Application for a non-material amendment following a grant of planning permission.

Number	<input type="text"/>
Suffix	<input type="text"/>
Property name	Ashurst House
Address line 1	The Coppice
Address line 2	Lower Bitchet
Address line 3	<input type="text"/>
Town/city	Bitchet Green
Postcode	TN15 0ND
Description of site location must be completed if postcode is not known:	
Easting (x)	556422
Northing (y)	154241
Description	<input type="text"/>

Extensions, internal alterations and alterations to fenestration to the existing dwelling. Extension to existing garage to allow for the creation of a third bay/carport with new roof. Enlarged driveway and general landscaping works to include the removal of some trees and the formation of an enlarged terrace area with swimming pool. Conversion of the existing outbuilding to form a pool house.

Reference number:	<input type="text" value="20/01611/HOUSE"/>
-------------------	---

Title  
Proposed Elevations and Section

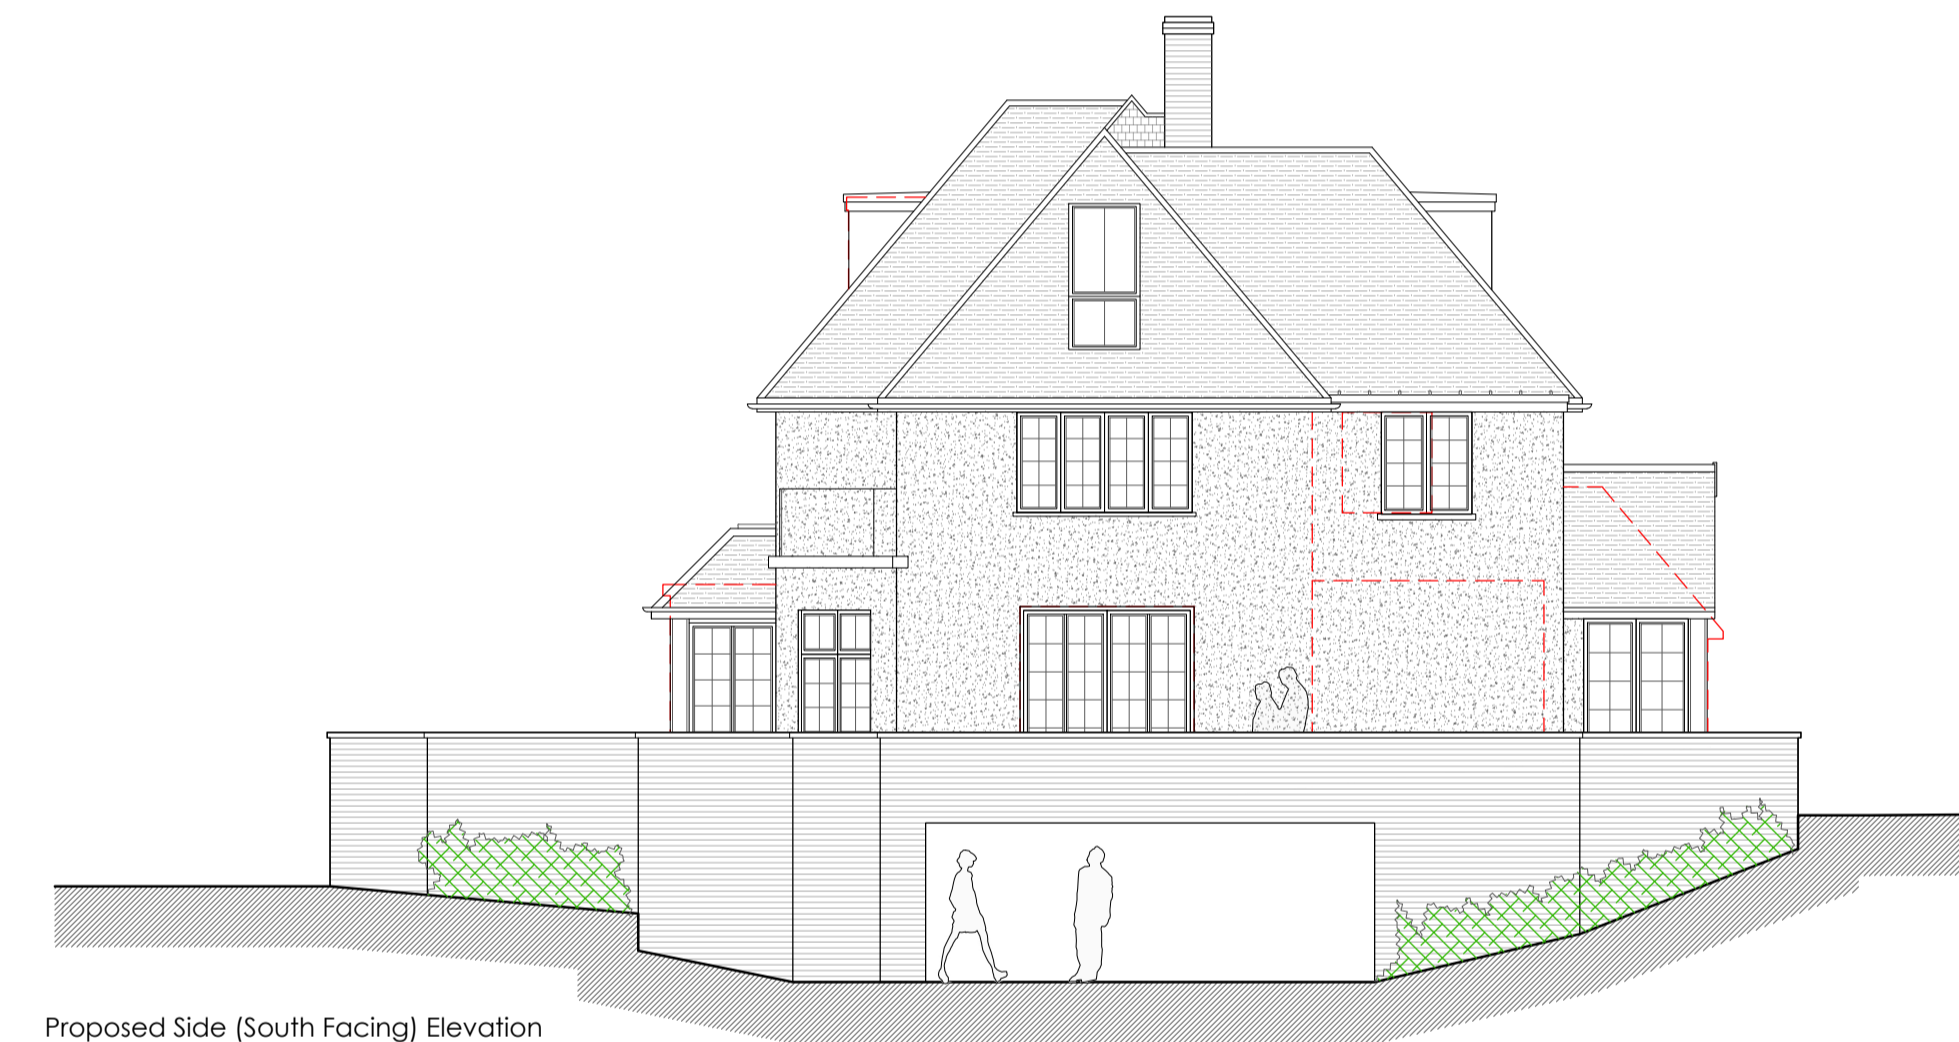
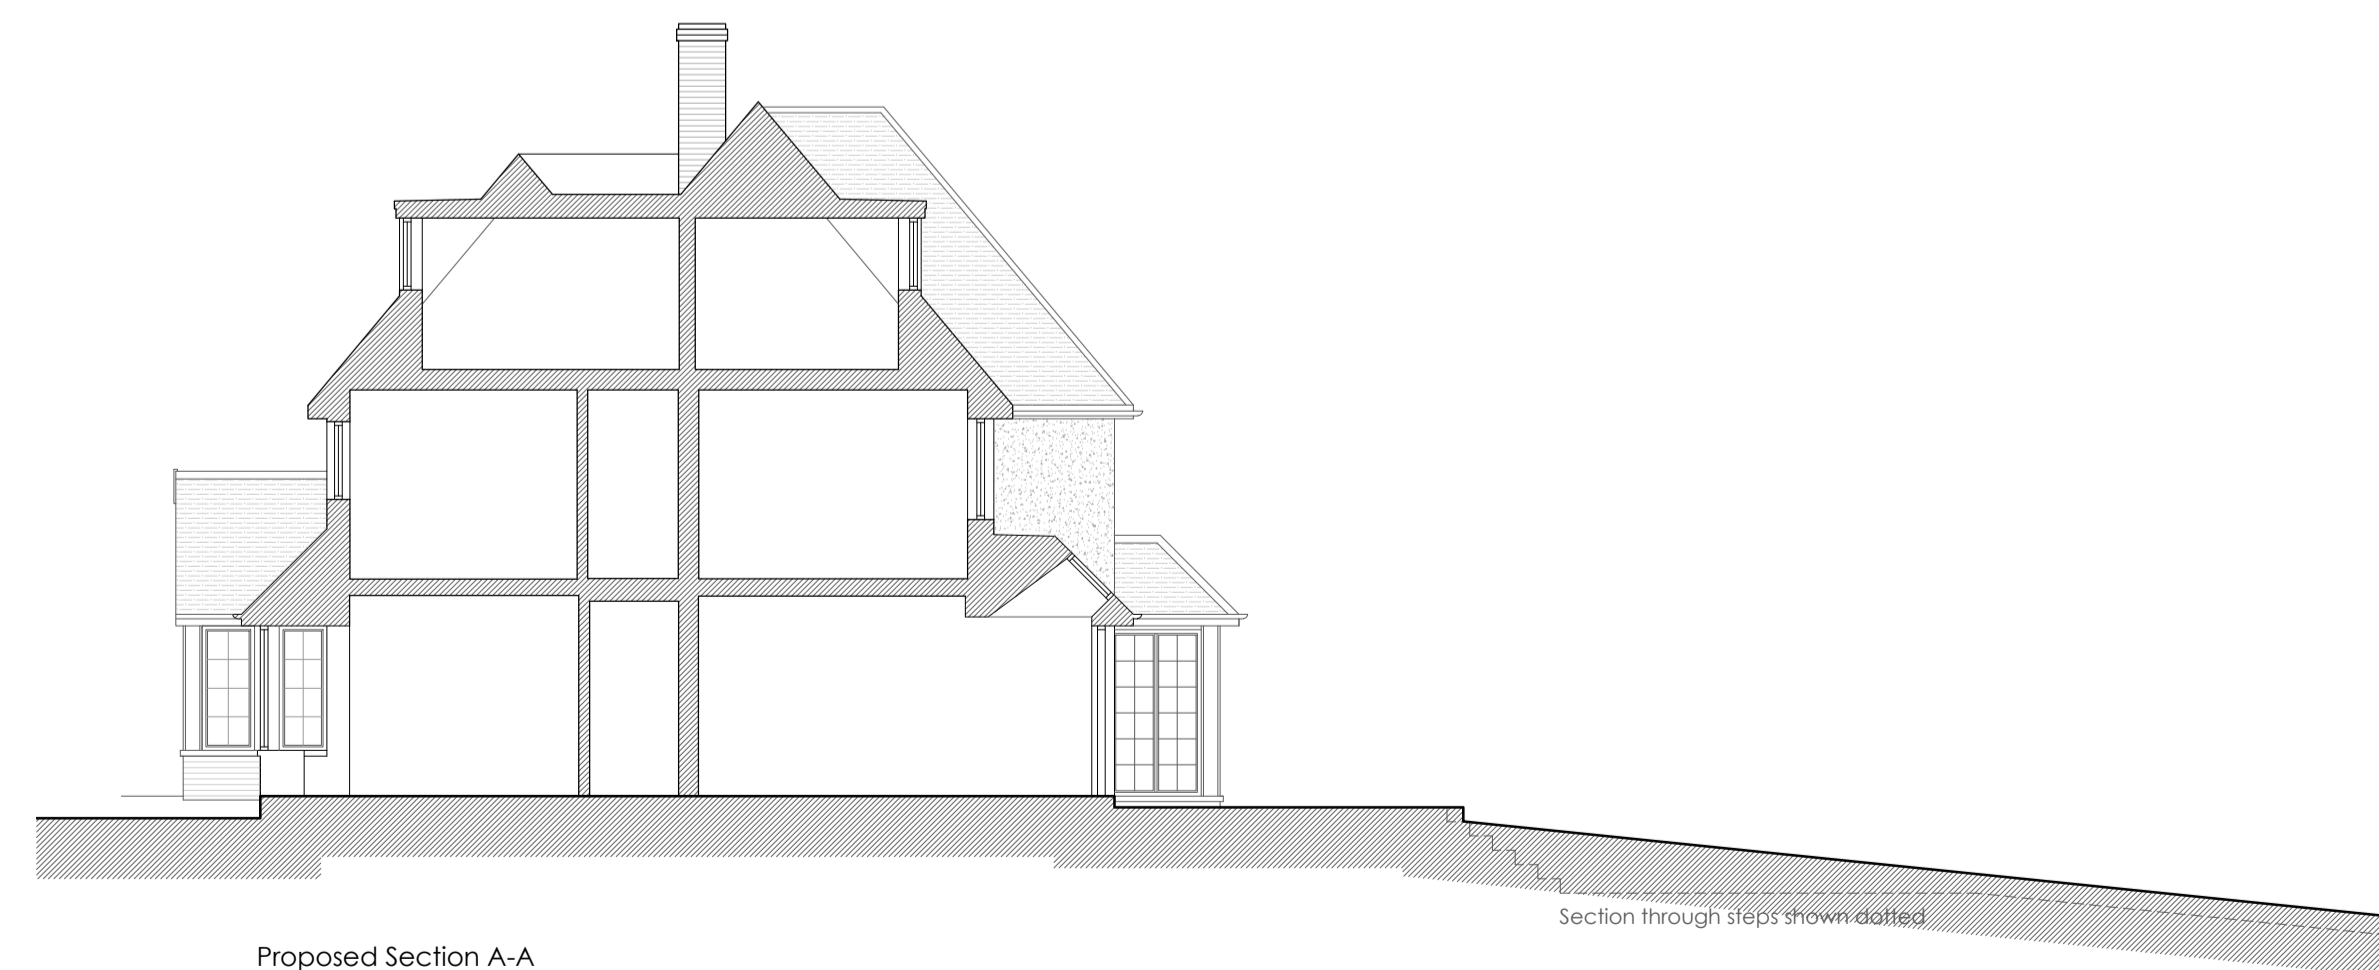
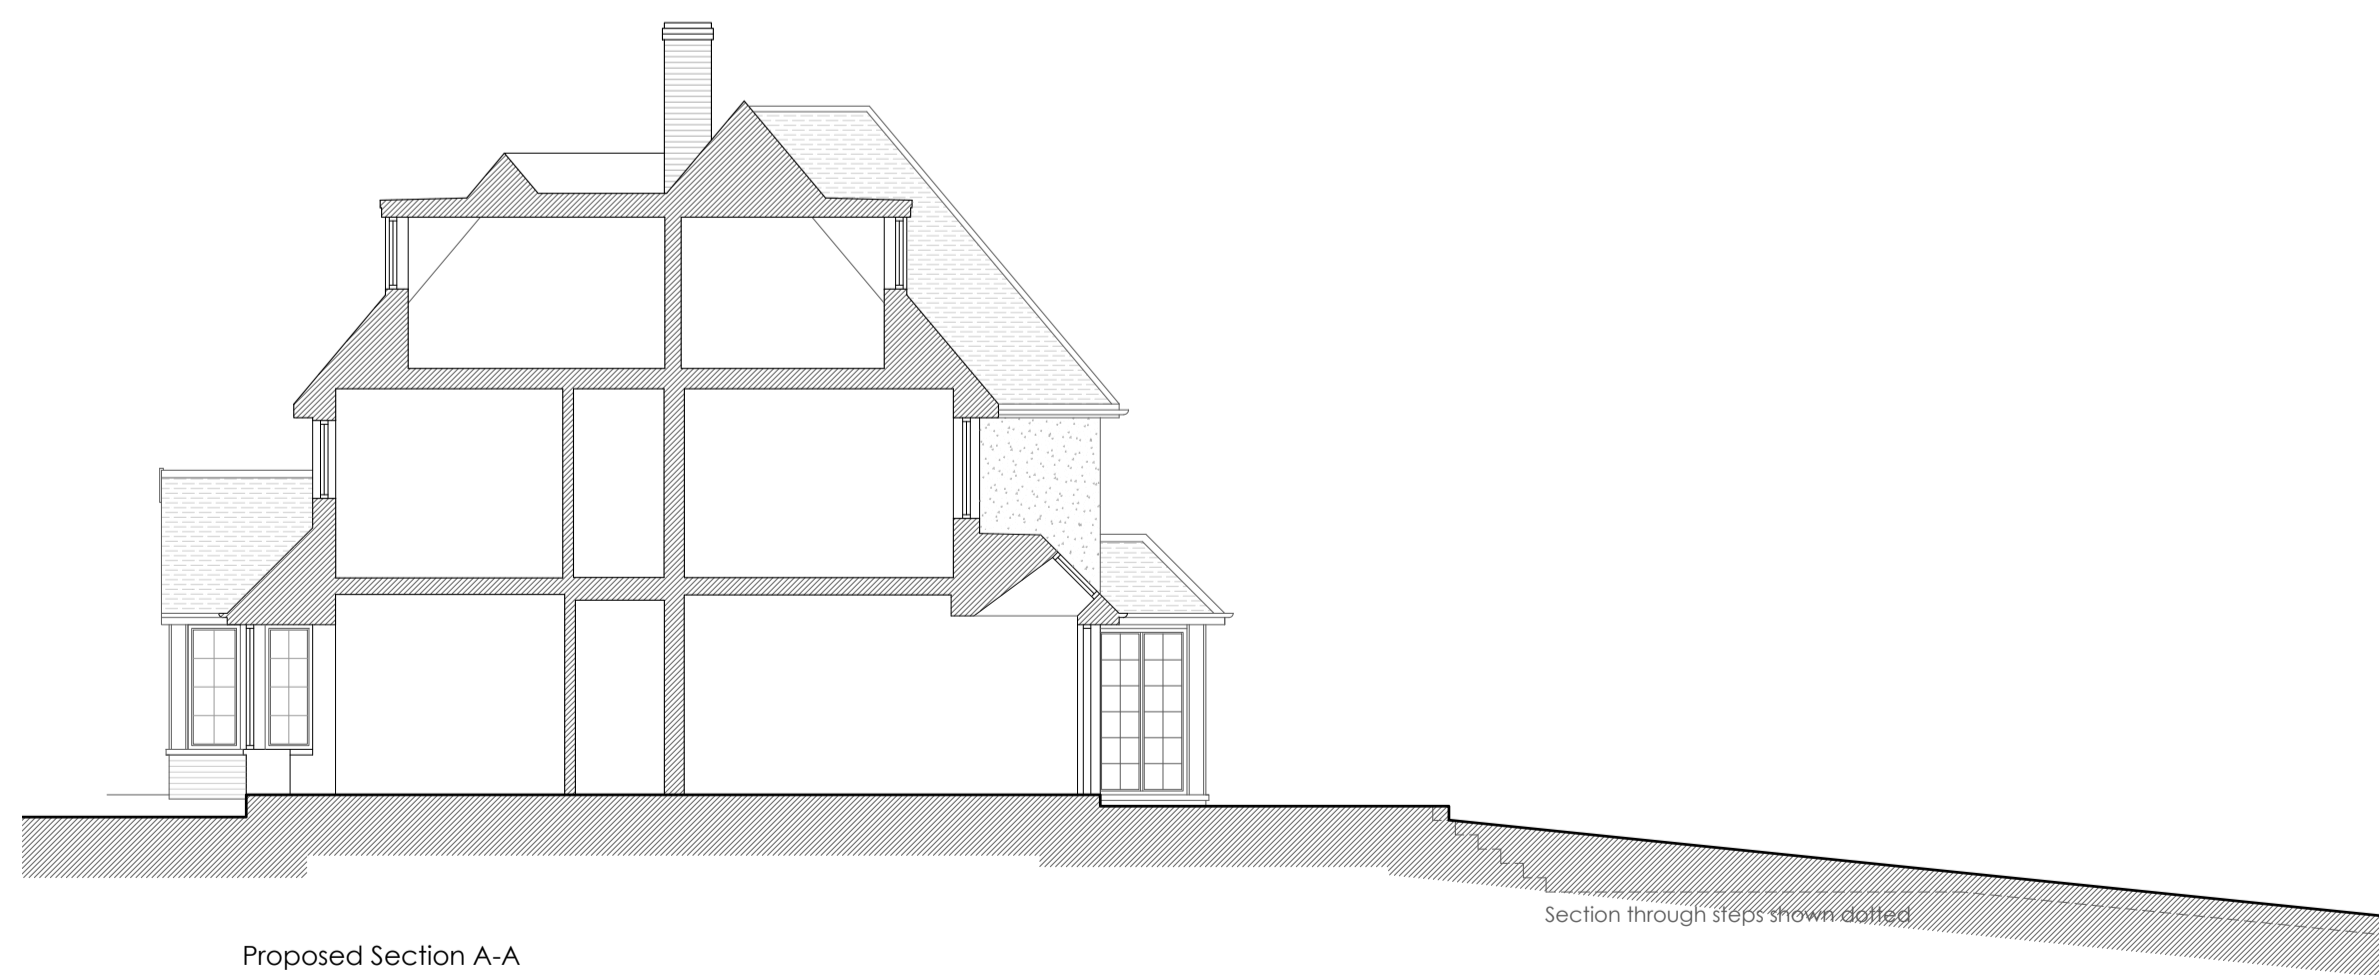
To replace / cover the existing pebbledash render with a textured render. The colour will be an off - white / light cream.

This existing pebbledash render is past its serviceable life with many historic patch repairs. This is to cover the existing repairs and tie in with the new extensions to provide clean uniform elevations.

6786-PD-06 Rev B
